MECKLENBURG COUNTY
Park and Recreation Department

MEMORANDUM

RE: Rezoning Petition # 2008-035 (PID #s 075-105-43; 075-105-30; 075-105-37;
079-044-02)

SP101

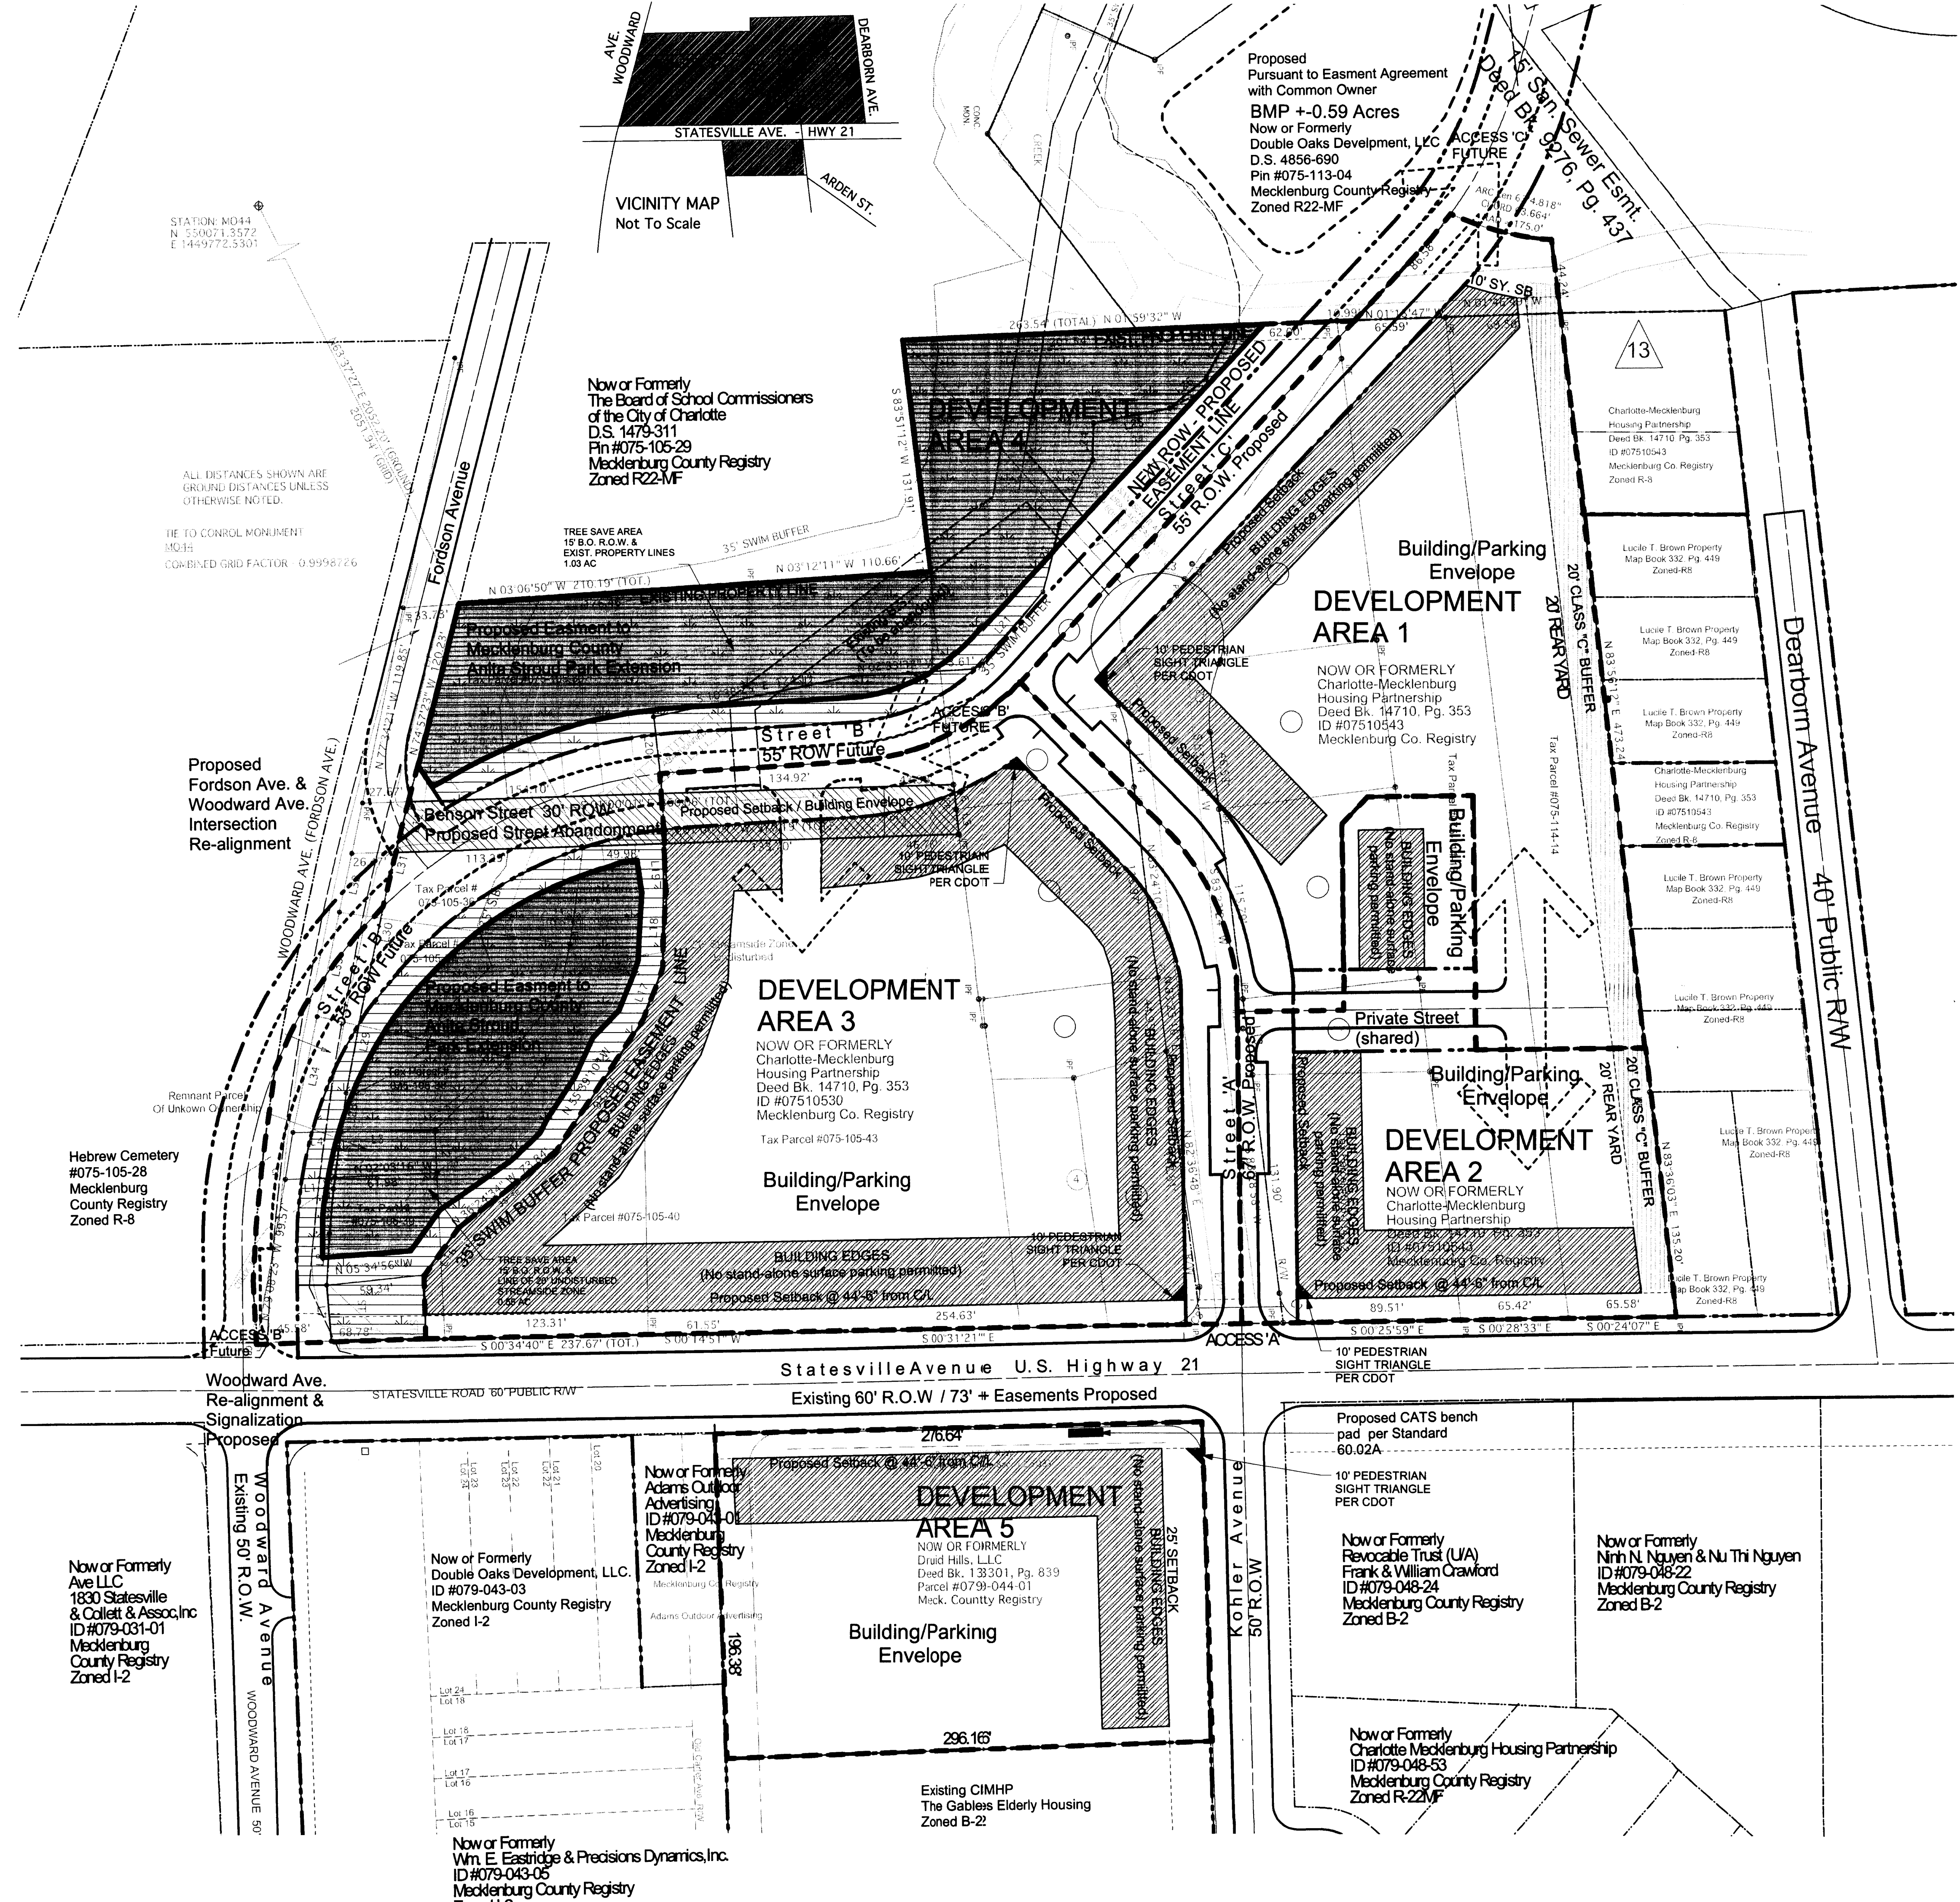
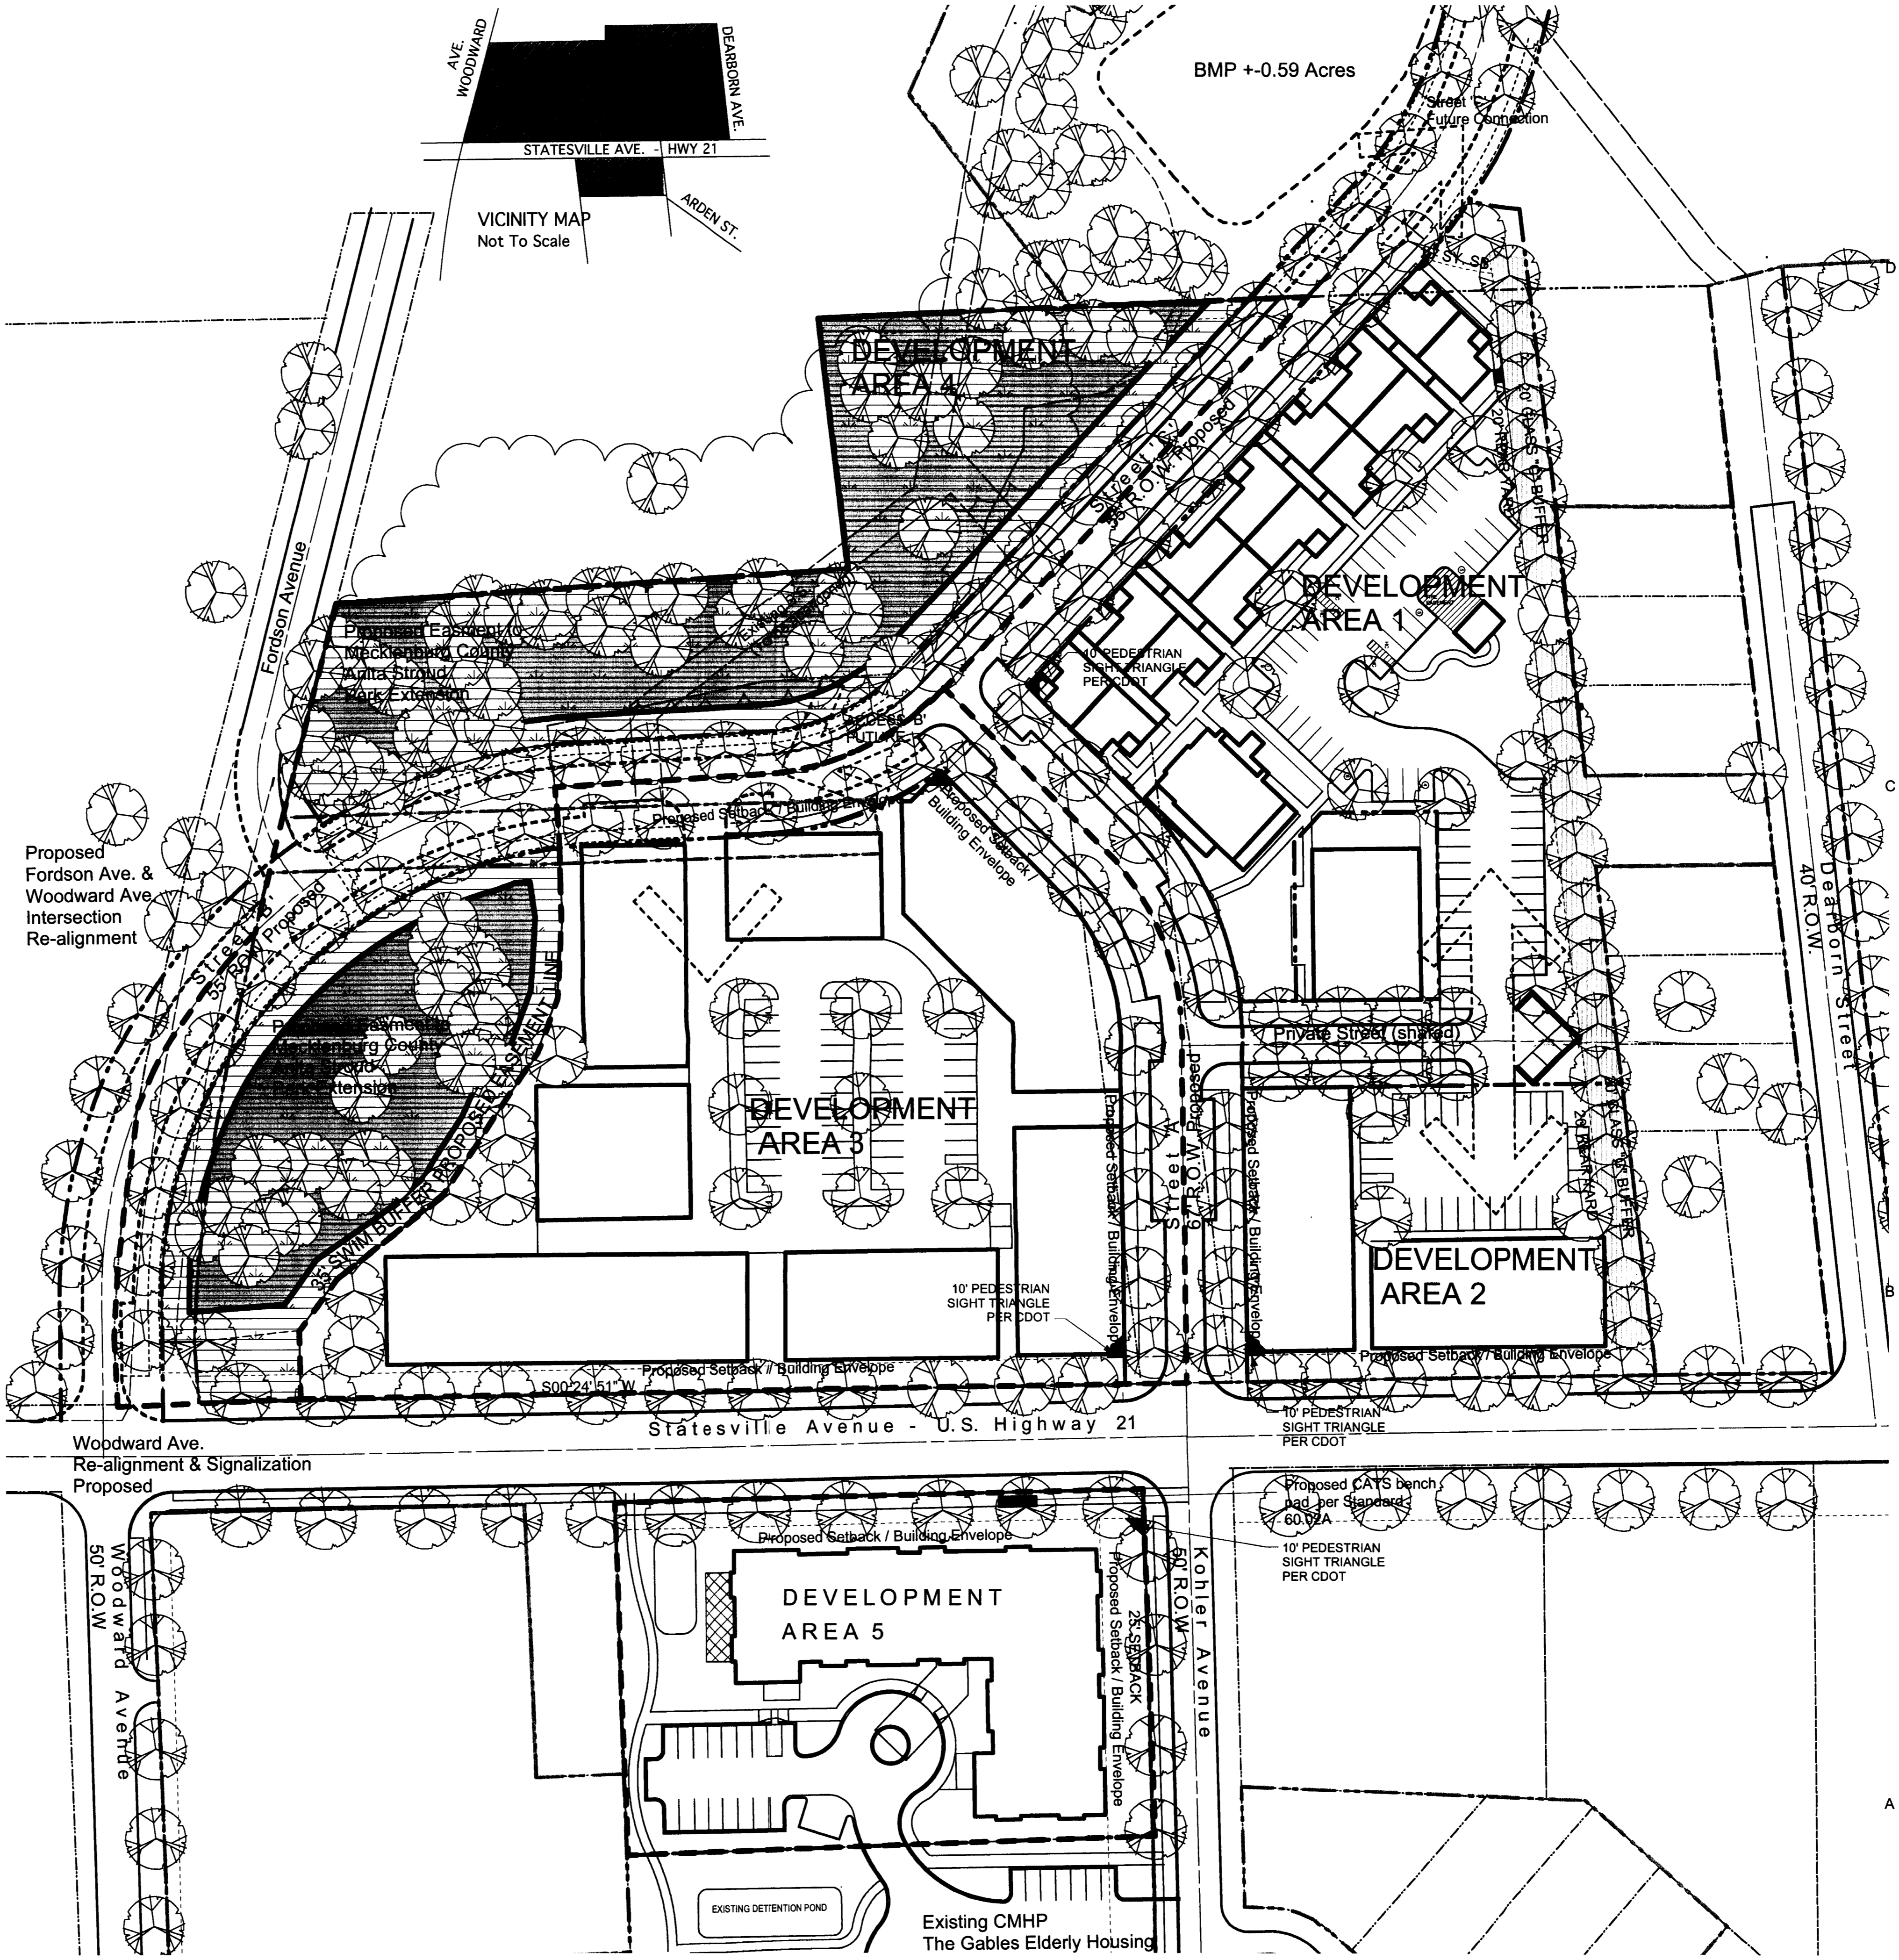
In most cases MCPR requests that the petitioner dedicate the FEMA floodplain or S.W.I.M. buffer to the County for floodplain protection and greenway development. On the site plan dated 12/20/07, the petitioner has offered an easement encompassing the 35' SWIM buffer. MCPR is appreciative of this offer. However, this site presents challenges that require additional easements or dedications for a greenway to be constructed. MCPR requests an easement or dedication of the entire area of "Development Area 4" that is on the northern side of the

proposed Woodward Avenue. This will provide additional area to route the greenway and also allow for a connection to the public sidewalk system at the intersection of Woodward Avenue and Kohler Avenue. Additionally, MCPR requests that the reconstructed Woodward Avenue bridge over the Irwin Creek tributary be built to accommodate an 8' wide greenway trail with a minimum clearance of 7'6" underneath the bridge on the eastern side of the tributary. MCPR also requests an easement or dedication of additional land at the intersection of Woodward Avenue and Statesville Avenue to enable the greenway to fully reach the intersection. The additional dedication should be a minimum of 180 square feet and should form a straight line between the 35' SWIM buffer easement line and Statesville Avenue as shown on the site plan.

MCPR also wishes to note that additional land outside of the area encompassed in this rezoning will be required to connect the proposed easements to Anita Stroud Park. This approximately 200' gap exists north of the area entitled "Development Area 4" and adjacent to the proposed BMP as shown on the site plan.
